**Surrey Heath Borough Council Deadline 6
Submission**

Esso Petroleum Company Limited
Southampton to London Pipeline Project
Application for a Development Consent Order

Project reference no. EN070005

Hearing Action Points arising from the Issue Specific Hearing on the draft Development Consent Order (dDCO) held at the Village Hotel Farnborough on Tuesday 25 February 2020

Drawing title: **TURF HILL: CONSTRUCTION STAGE**

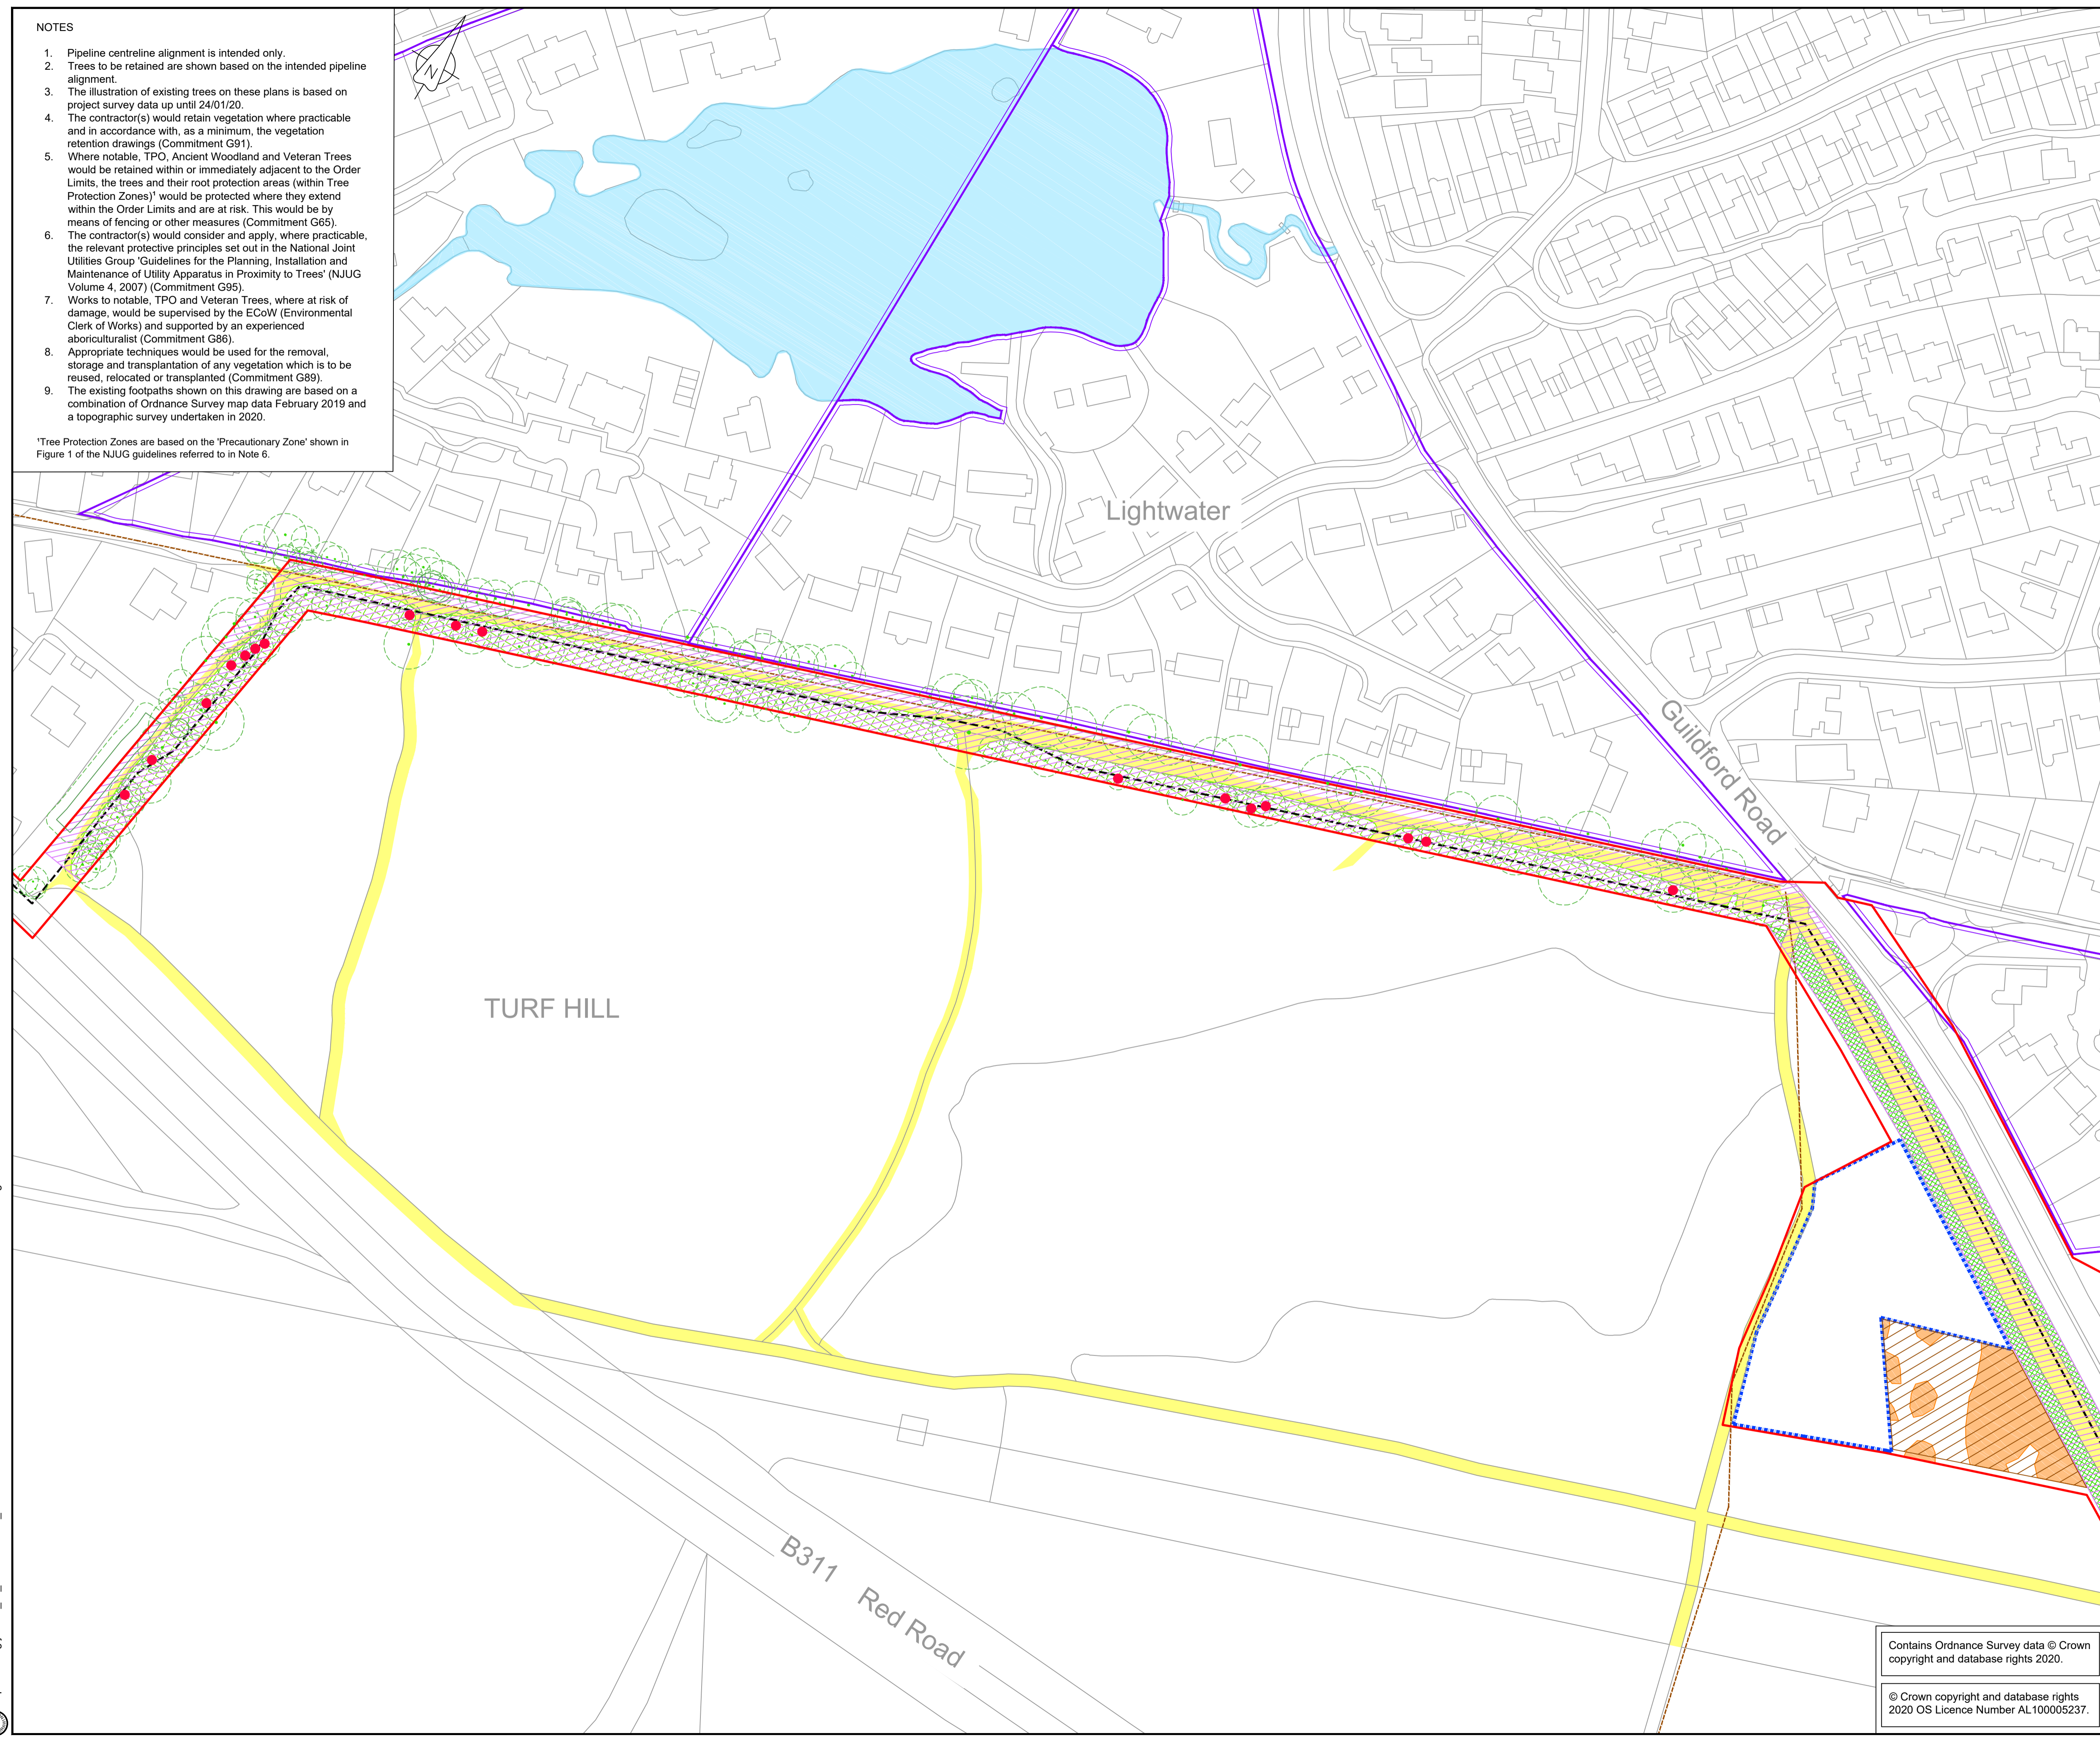
The Council understands that the Heronscourt and Colville Gardens Residents Associations are very concerned about the potential loss of a significant number of trees in the Turf Hill area as a result of construction activities. Whilst the Council welcomes the Site Specific Plan for Turf Hill and notes that it is a step in the right direction to addressing and mitigating the potential significant impacts in this area, the Council and the Heronscourt and Colville Gardens Residents Associations are of the opinion that information submitted in respect of potential tree losses are lacking the necessary detail.

At Deadline 4 the Heronscourt and Colville Gardens Residents Associations provided a detailed submission in respect of the Applicants Arboriculture Report for Turf Hill. The Council requests that the Examining Authority seek further clarifications from the Applicant in respect of the evidence and concerns outlined by the Residents Associations throughout the Examination and in the Deadline 4 submission referencing Mr Hogg's report (Examination document 1159).

As previously requested by both the Council and the Heronscourt and Colville Gardens Residents Associations the Council welcomes confirmation that a survey in full compliance with BS5837:2012 of the trees in Turf Hill, including those along the Guildford Road, is to be undertaken by the Applicant. However it is concerning that such fundamental information to enable an informed assessment of the impact of tree removal to facilitate the pipeline in both amenity (residential and visual) and ecological terms and the likely protection/mitigation measures required to address the identified impacts is to be submitted so late in the Order process. At the hearing held on 26 February 2020, the Applicant's tree consultant advised that all replacement tree planting, on a one for one basis, would take place within the Order limits. Firstly we would draw the Examining Authority's attention to our submissions at Deadlines 4 and 5 where the Council confirmed that it would expect to see a minimum of two replacement trees for each mature tree removed with replacement trees being standard, root balled, of between 15 -20 years of age and broad leaf native species. Secondly the Site Specific Plan for Turf Hill makes it clear that replacement planting would take place outside of the 6.3 metre pipeline easement. This ongoing lack of clarity is unhelpful at this stage in the Examination process to both the Council and the Heronscourt and Colville Gardens Residents Associations
